From: [REDACTED]
To: [East Anglia ONE North](#)
Cc: [East Anglia Two](#)
Subject: Response by St Peter's Church to proposed footpath changes at Theberton
Date: 25 March 2021 18:21:29
Attachments: [PCC RESPONSE SPR FOOTPATH.docx](#)

Please find attached the response by the PCC of St Peter's church Theberton and Eastbridge to proposed footpath changes on the B1122 in Theberton.

TITLE  
LINK 4b (B1122 - LEISTON ROAD)  
MITIGATION MEASURES

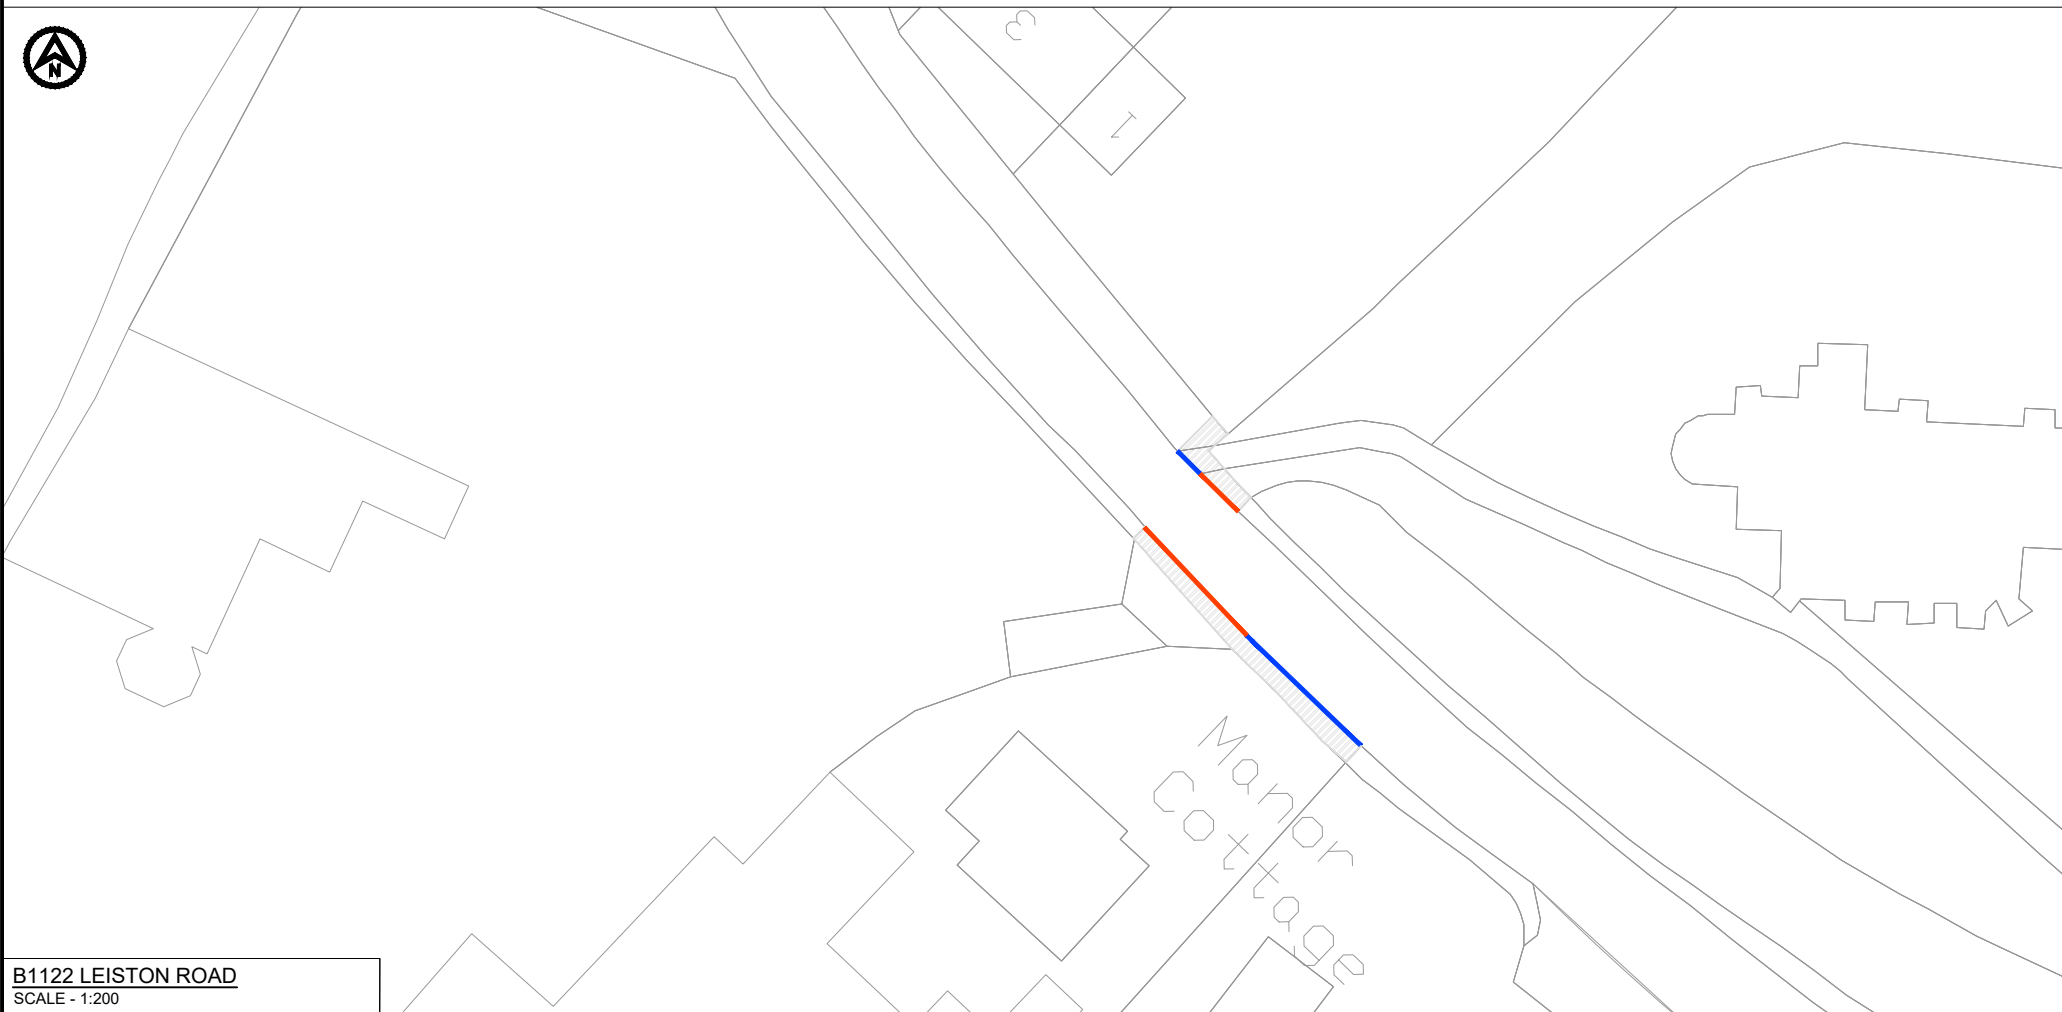
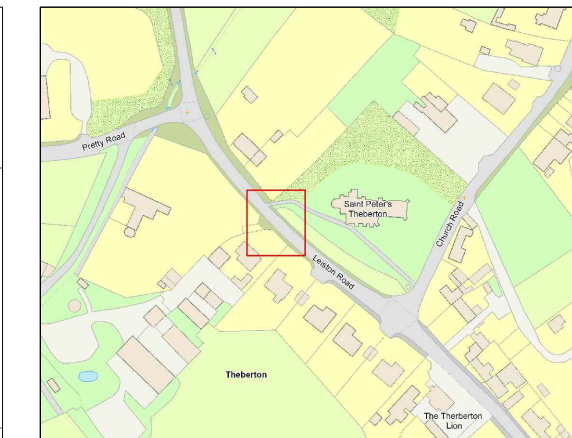
Whilst the PCC welcome the extension of the footpath west of the B1122, the visibility of the crossing point of the B1122 by Pretty Road is poor especially from East to West and should not be encouraged.

The plan is not clear as to how much of the bank will be taken north of Church Road and we understand that detailed plans will follow which will show this.

The PCC is concerned the effect this part of the proposed development might have on the stability of the wall and it's affect on the setting of the listed War Memorial.
